Subject: P/114/24/RES

Land west of Pagham Road Pagham.

I have reviewed the reserved matters applications above holistically, and with regards to ecology and Biodiversity Net Gain.

Recommendation: Hold for further details on pond specification, Bird and bat boxes on the dwellings, comments relating to the management plan and management of the ecological features.

ATTENUATION BASIN 1 DETAIL

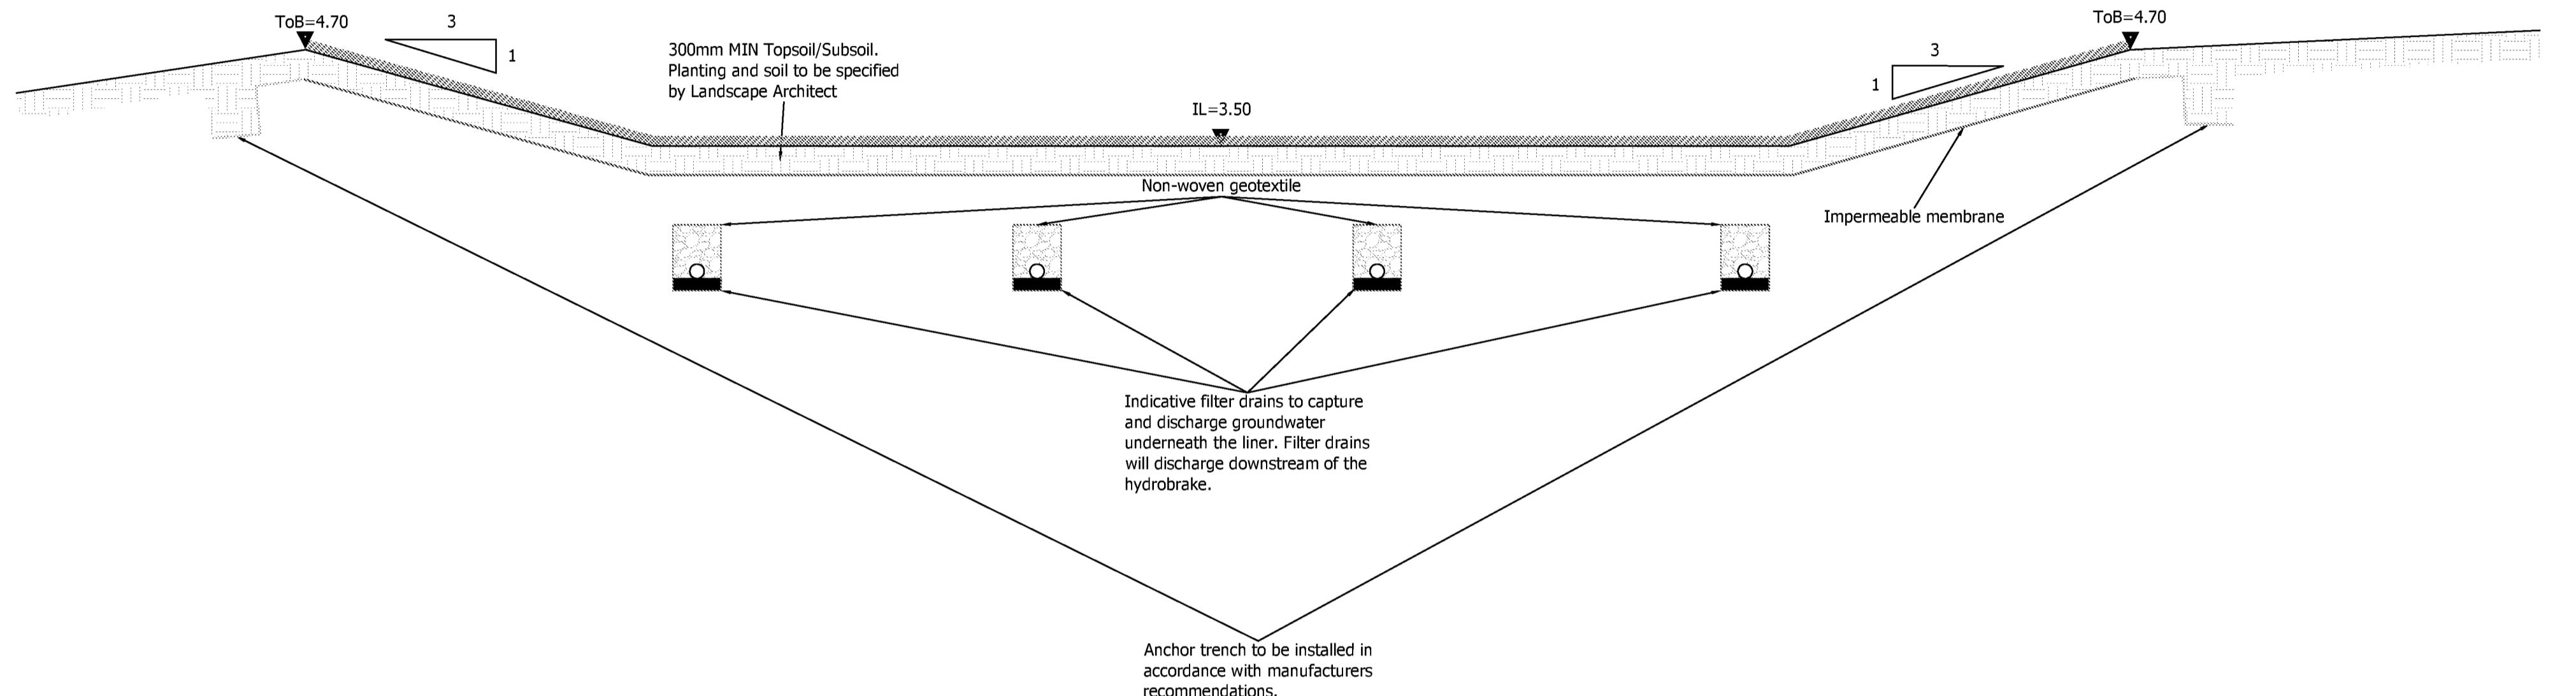
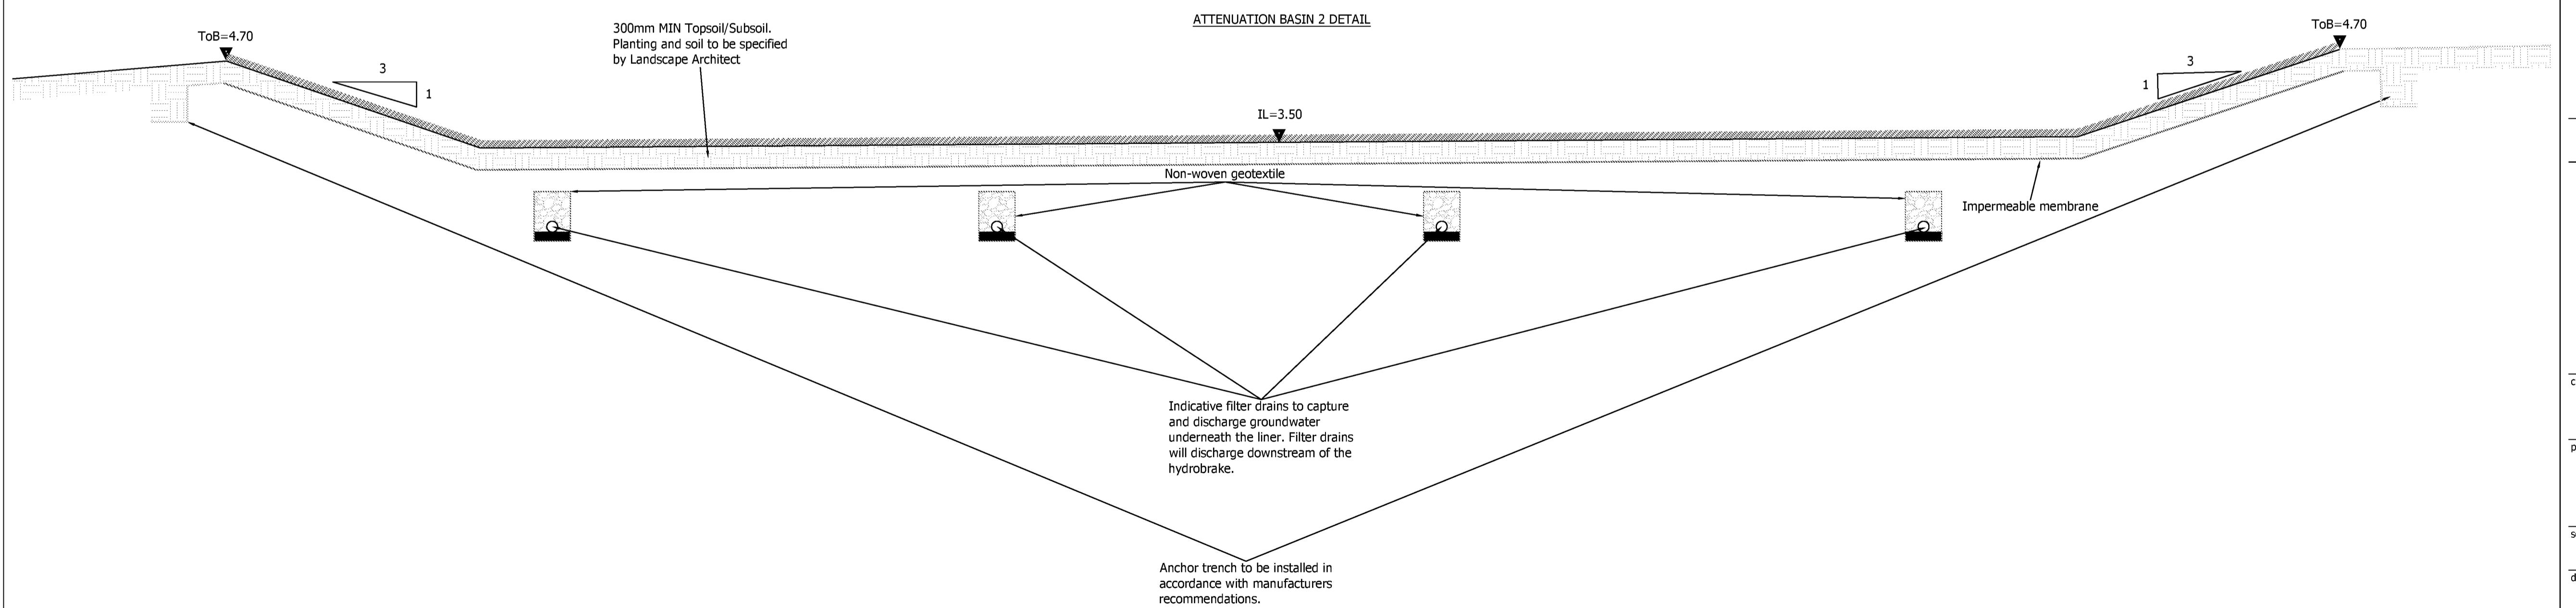
Guidance from the Freshwater Habitats Trust suggests that the ideal side of a pond for wildlife is 1:5 where the drainage information show a steeper 1:3 side.

Soft Landscape Strategy Plan

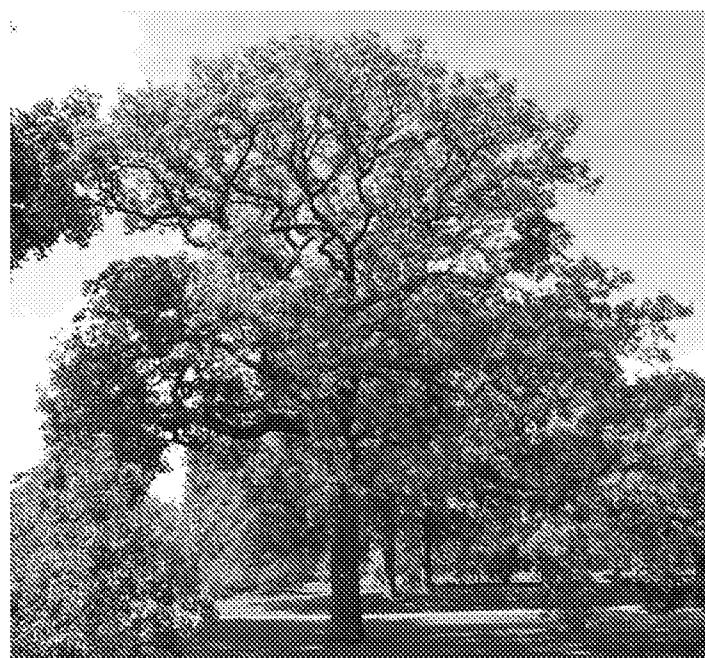
Planting species mix fine but only two of the species recommended in the ecological assessment 2021 are included in the planting schedule. There are 16 Trees in the meadow grass shown in plan D3322-FAB-00-XX-DR-L-6005. I recommend reducing the number as meadow will be overshadowed.
